Rustington Parish Council

Our Ref: CW/CH/PLAN/26
Date: 25 February 2026

R/17/26/CLP - Lawful development certificate for the proposed creation of a rear dormer to allow additional head space in the loft conversion and the addition of two vellum windows to the front of the property - 31 Windmill Drive, Rustington

**PROPOSED FLOOR PLANS, ELEVATIONS,**

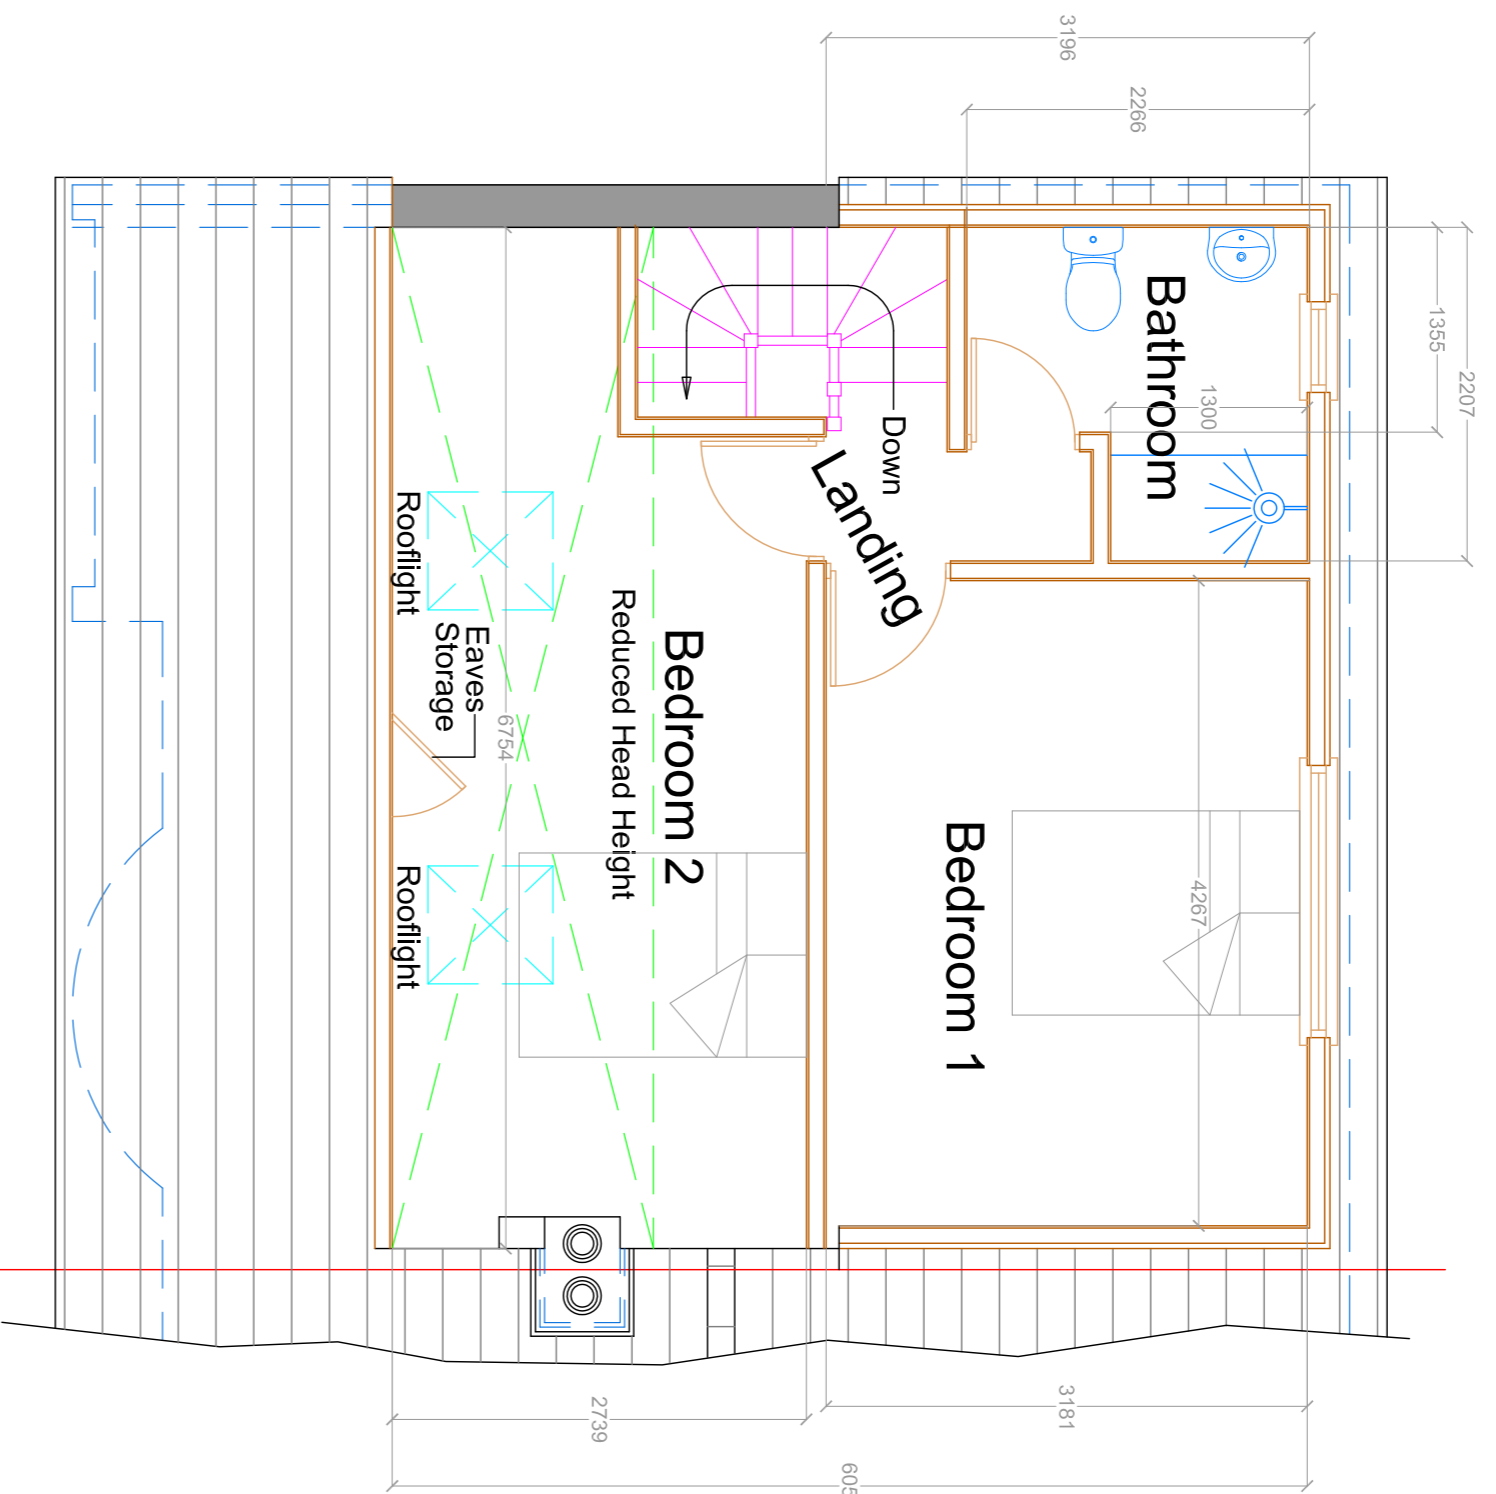
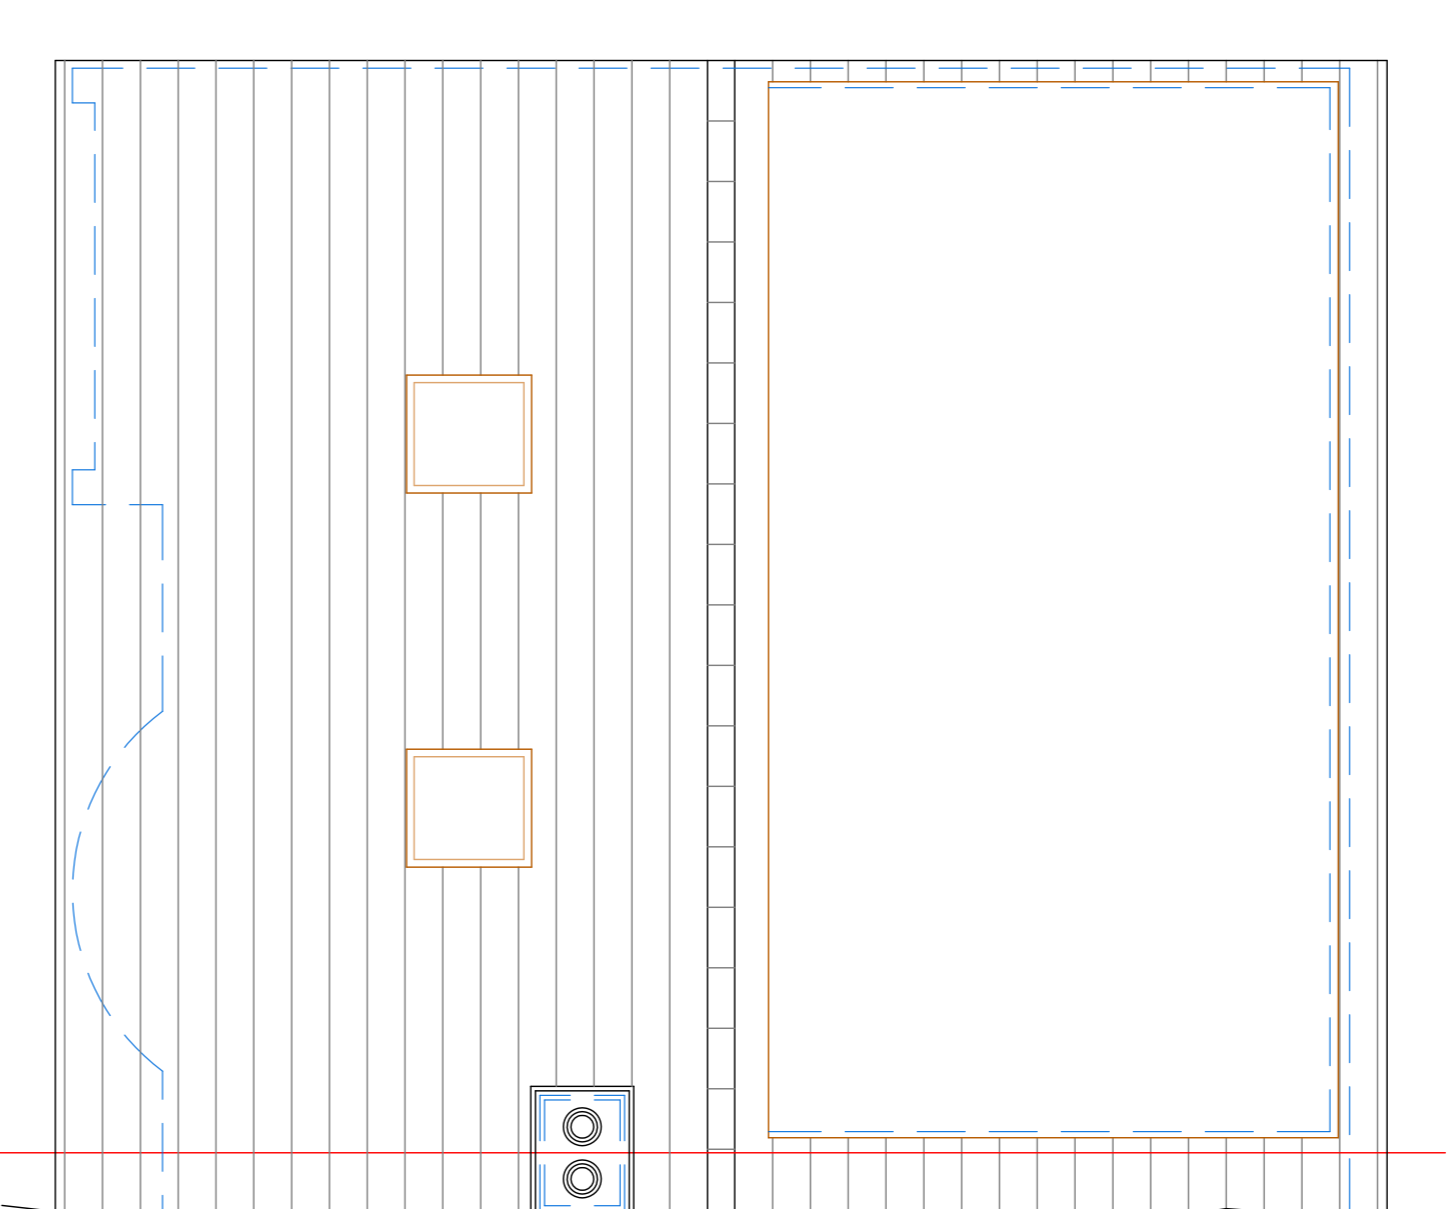
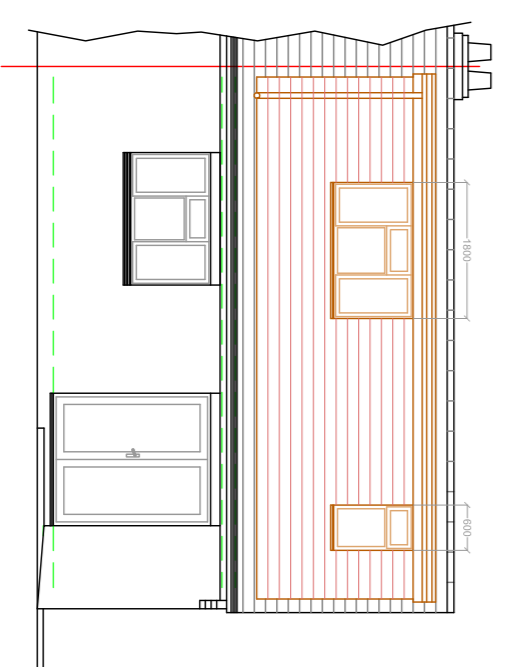
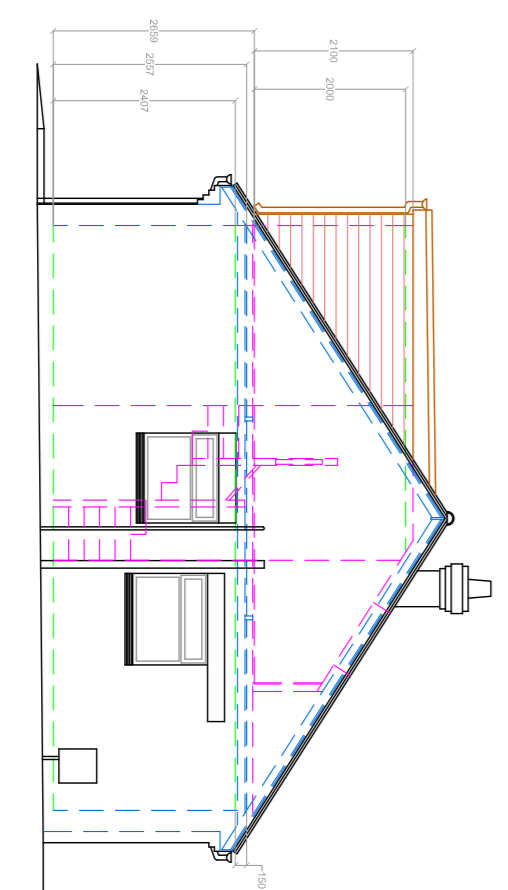
My Council has noted the above application and whilst it would not normally submit any comments in respect of Lawful Development Certificate Applications, in this instance, it believes that the plans for this application are inaccurate and somewhat misleading, as the external works have already been completed.
